OXFORDSHIRE COUNTY COUNCIL'S RESPONSE TO CONSULTATION ON THE FOLLOWING DEVELOPMENT PROPOSAL

Application no: 22/00747/OUT

Proposal: Outline planning application for the development of up to 370 homes, public open space (including play areas and woodland planting), sports pitches and pavilion, drainage and engineering works, with all matters reserved (appearance, landscaping, layout and scale) except for vehicular and emergency accesses to Bicester Road.

Response date: 13th May 2022

Access Strategy

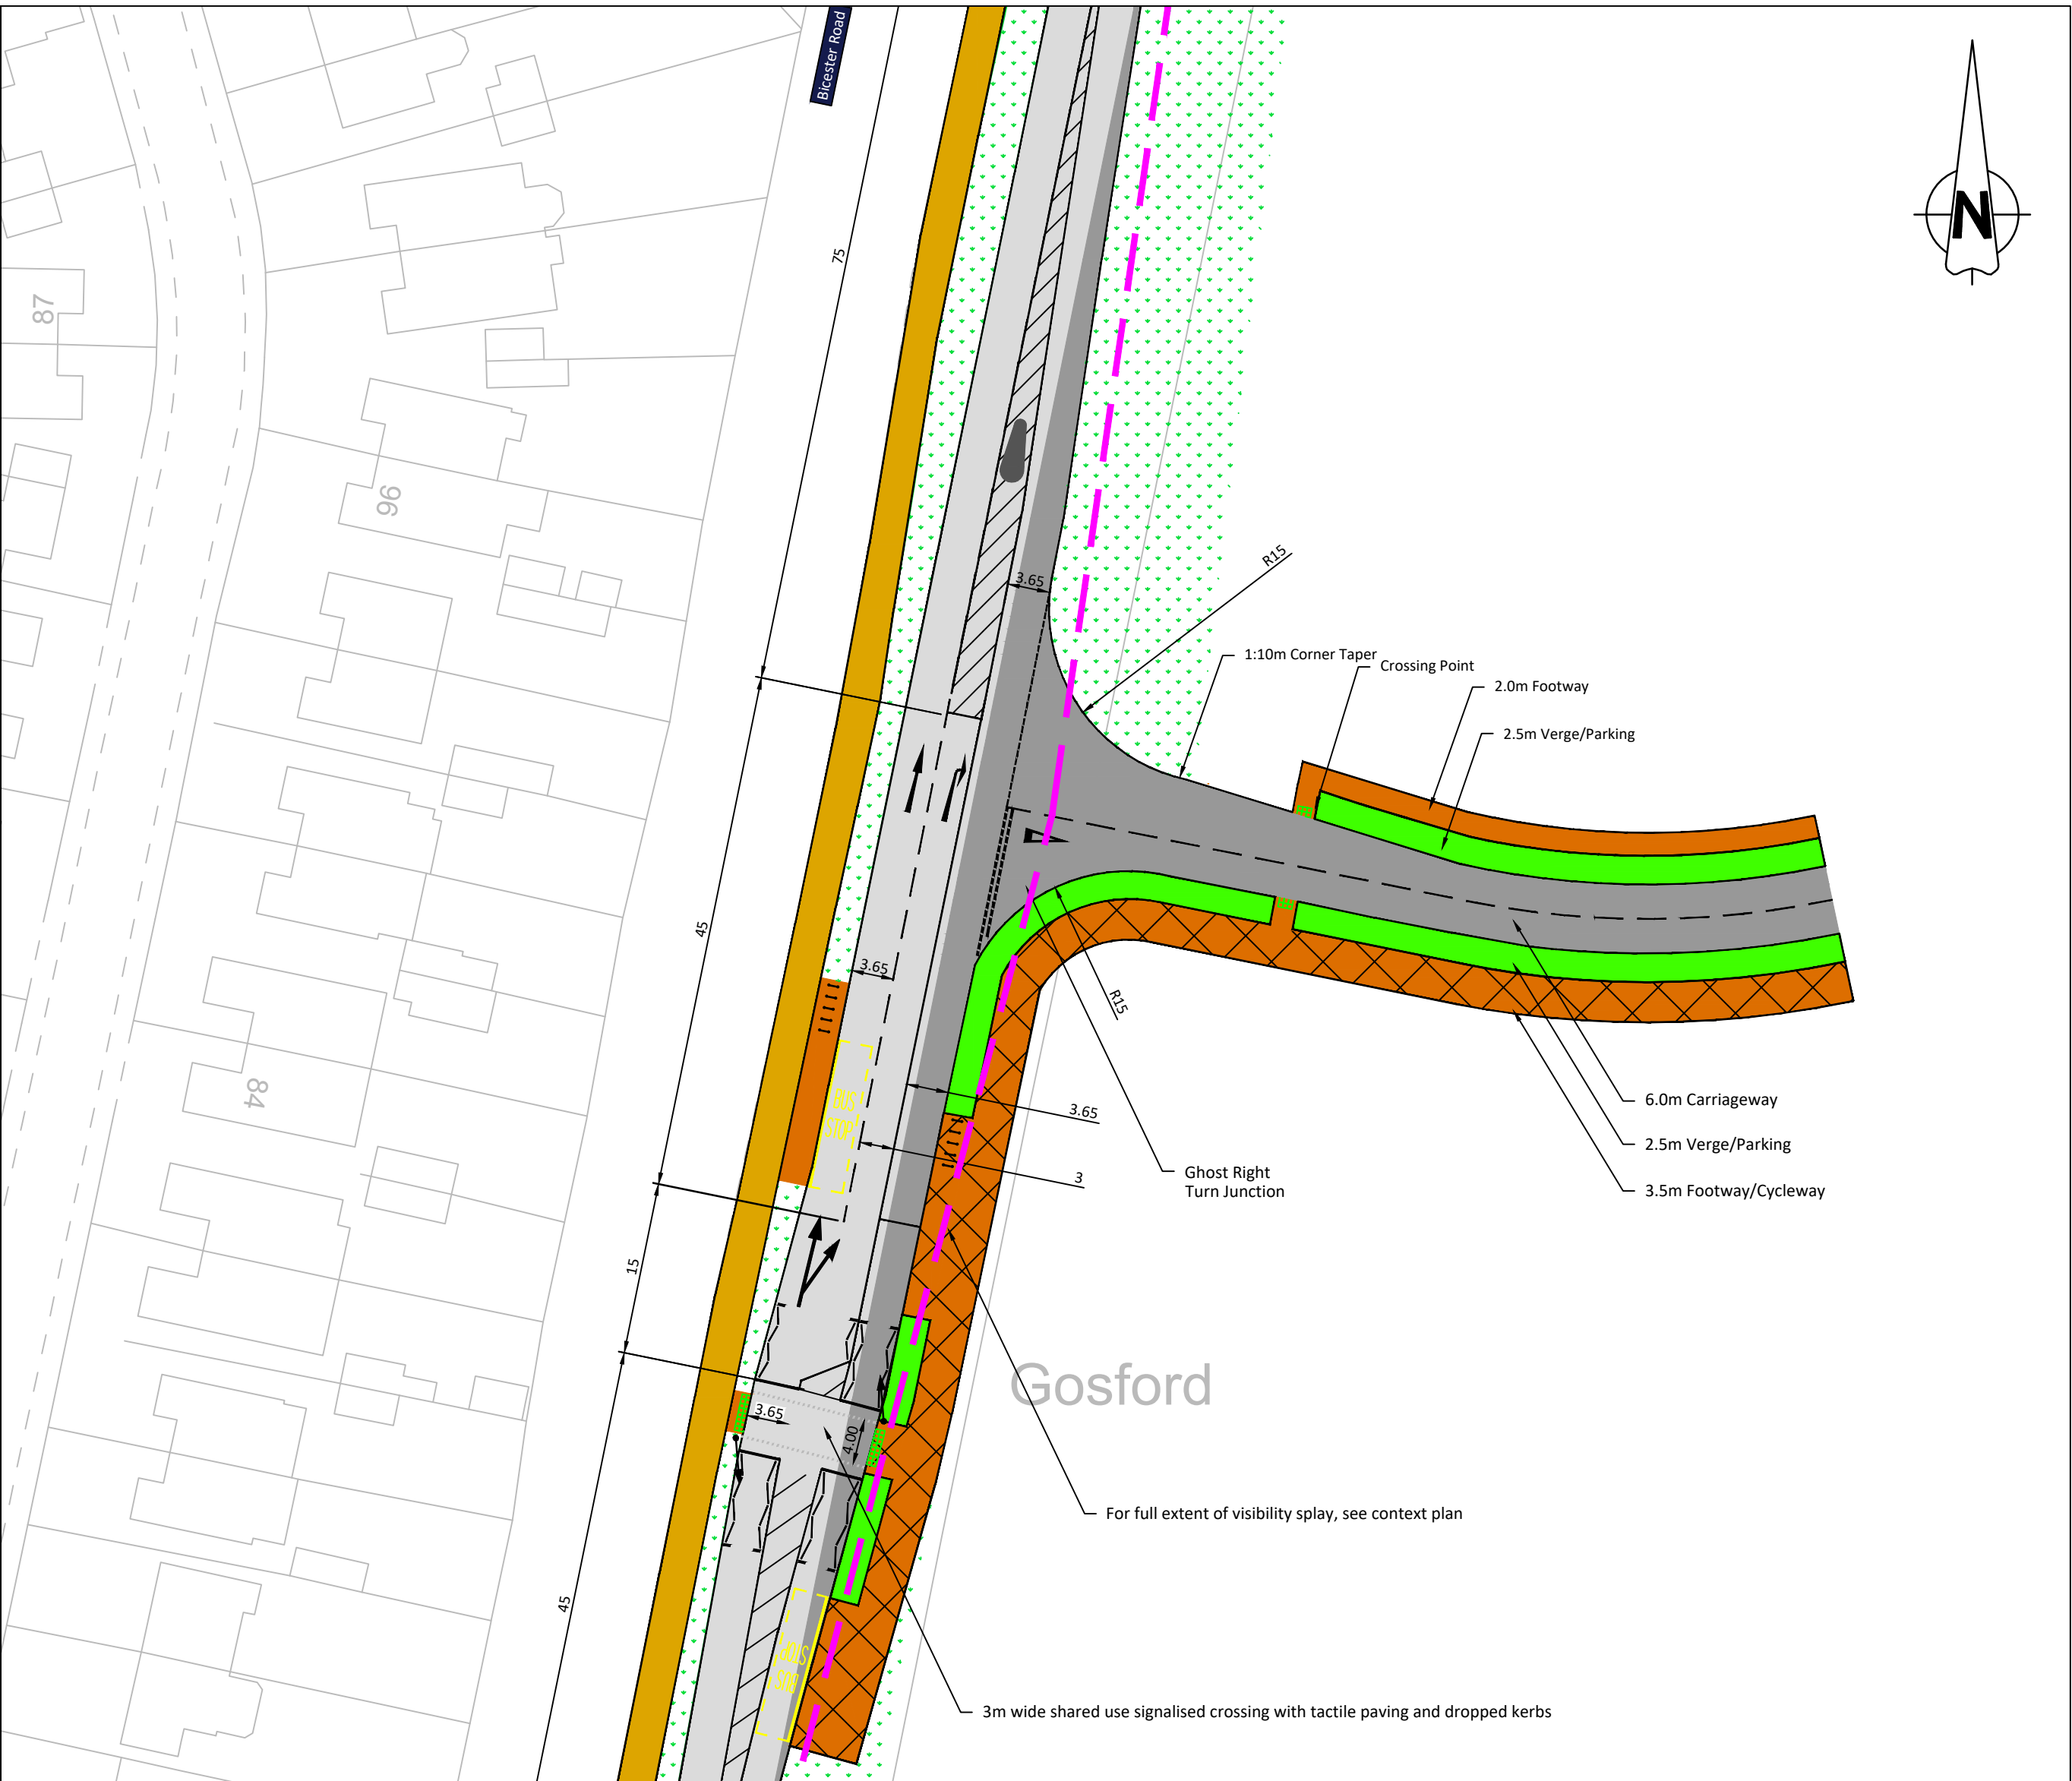
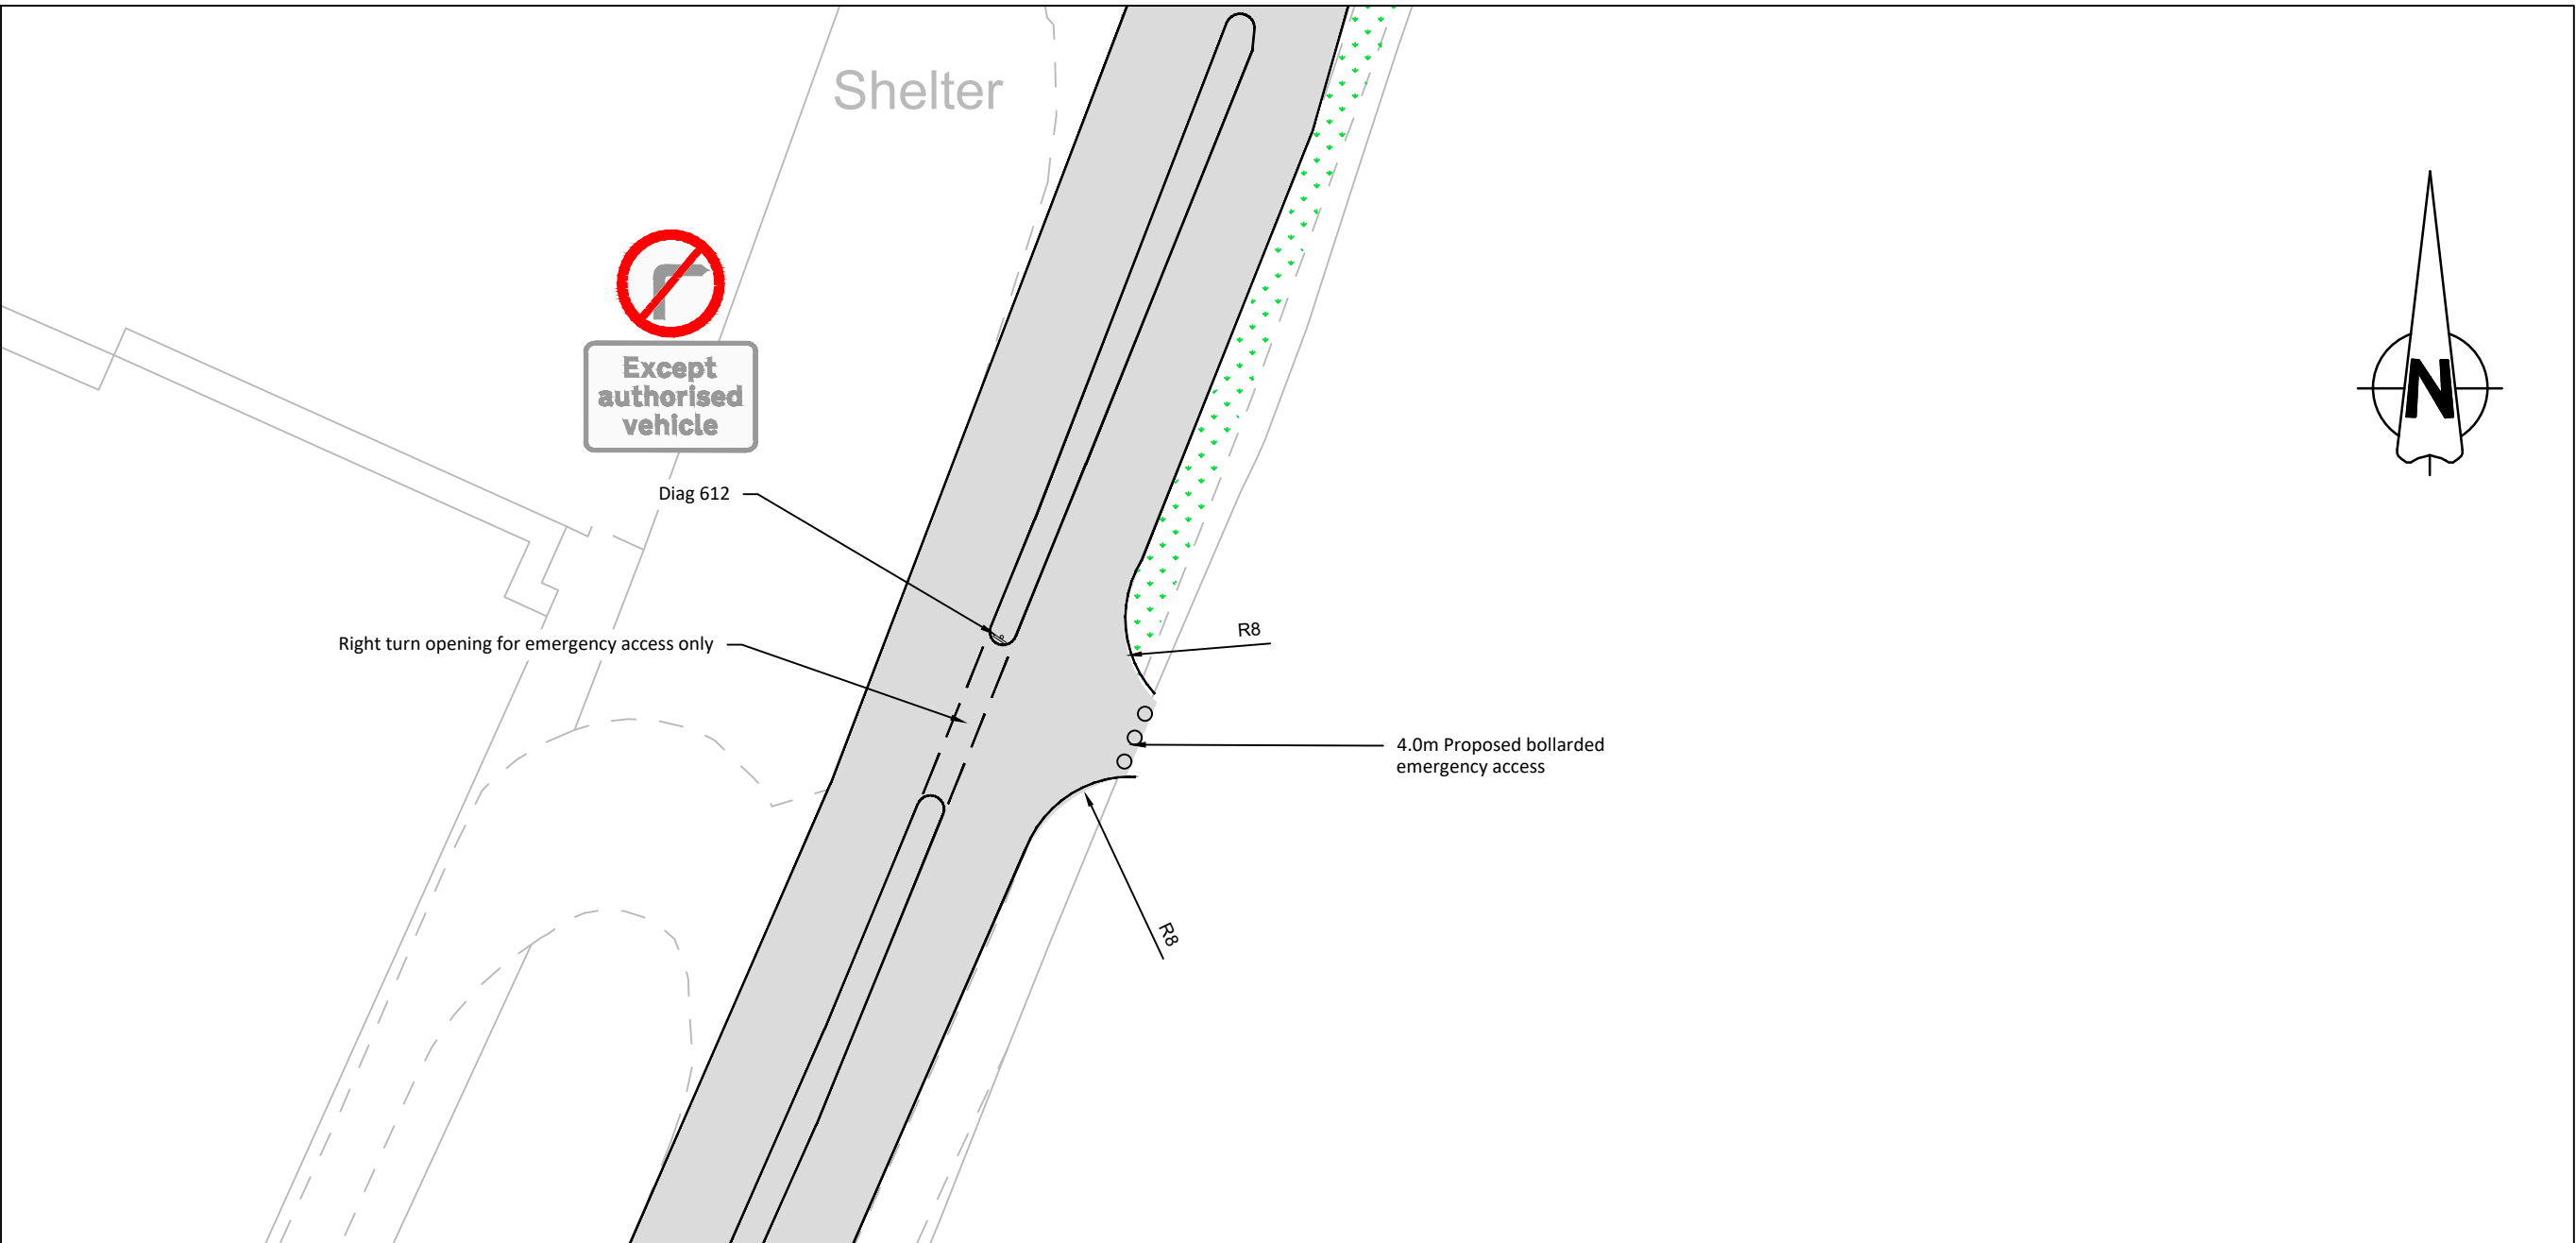
OCC welcomes the applicant's willingness to provide an additional pair of bus stops to maximise trips by public transport, as indicated in Para 3.10 of Technical Note 6: Response to Stagecoach. The additional pair of bus stops will need to be located around the secondary access that would directly serve the parcel of land to be brought forward by Hill Residential Ltd. An updated masterplan and access plan shall need to be submitted indicating the location and links to this stop.

With this in mind, the applicant needs to be drawn to OCC's consultation response dated 28th April 2022 where we identified the need to provide a new pedestrian crossing at the northern end of the site. Details of this crossing must be presented at the outset, to assess its suitability on matters such as type of crossing, adequate visibility, land availability, desired speeds on the approach and lighting. Again, it is difficult to resolve without the understanding of the comprehensive plan of the entire PR7a site.
